# KITTITAS COUNTY

## DEPARTMENT OF PUBLIC WORKS

**TO:** All Staff  
**FROM:** Public Works Plan Review Team  
**DATE:** April 15, 2026  
**SUBJECT:** SE-26-00003 Kittitas PUD 1 HQ

C1.0

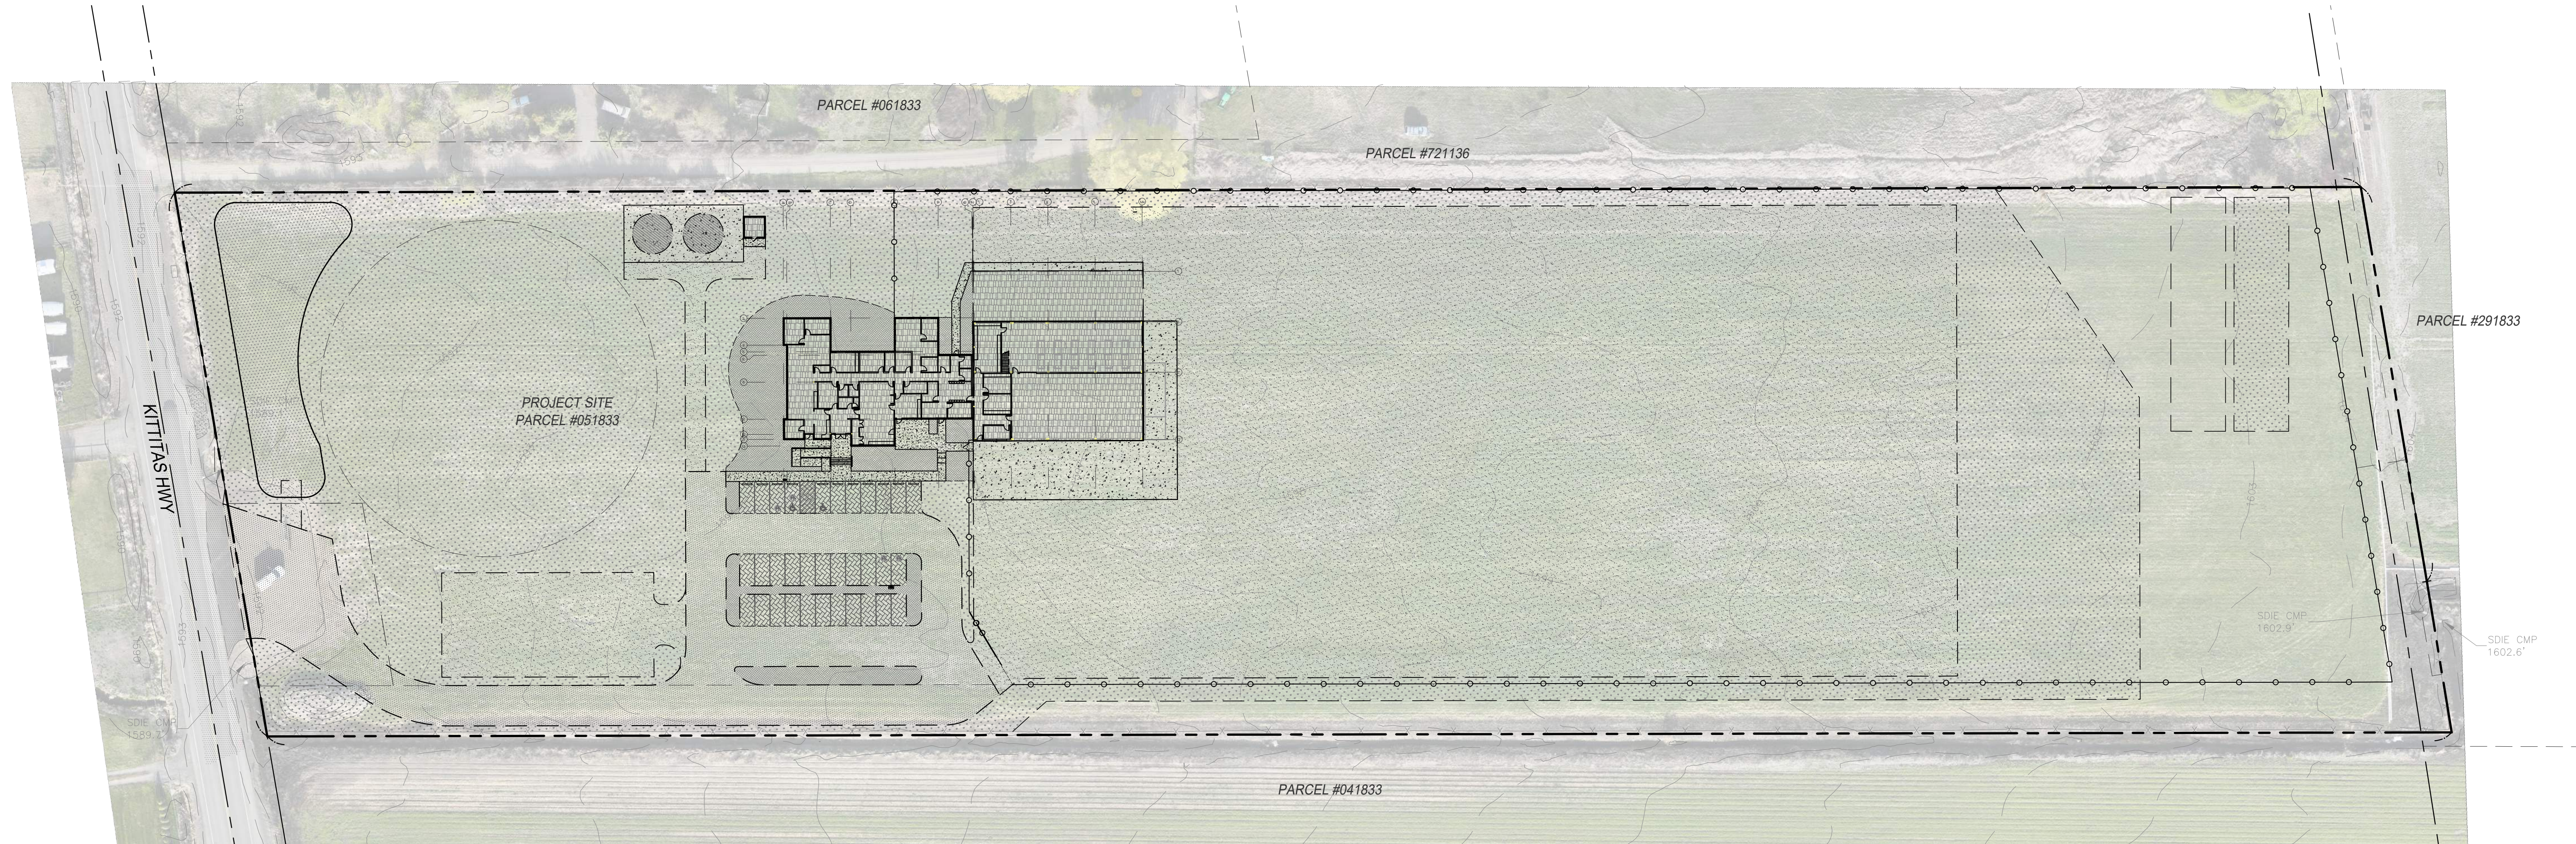
<b>ACCESS</b>	<ol style="list-style-type: none"> <li>1. Applicant has an issued Access Permit AA-24-00112 for commercial approach.</li> <li>2. Maintenance of driveway approaches shall be the responsibility of the owner whose property they serve. The County will not maintain accesses.</li> <li>3. Any further subdivision or lots to be served by proposed access may result in further access requirements. See Kittitas County Road Standards.</li> </ol> <p>In addition to the above-mentioned conditions, all applicable Kittitas County Road Standards apply to this proposal. Access is not guaranteed to any existing or created parcel on this application. (RC)</p>
<b>ENGINEERING</b>	Except as exempted in KCC 14.05.060, no grading or filling upon a site involving more than one hundred (100) cubic yards shall be performed without a grading permit from the County Engineer or Public Works designee (KCC 14.05.050). An application for grading in excess of five hundred (500) cubic yards shall be accompanied by an engineered grading plan (KCC 14.05.080). (CBP)
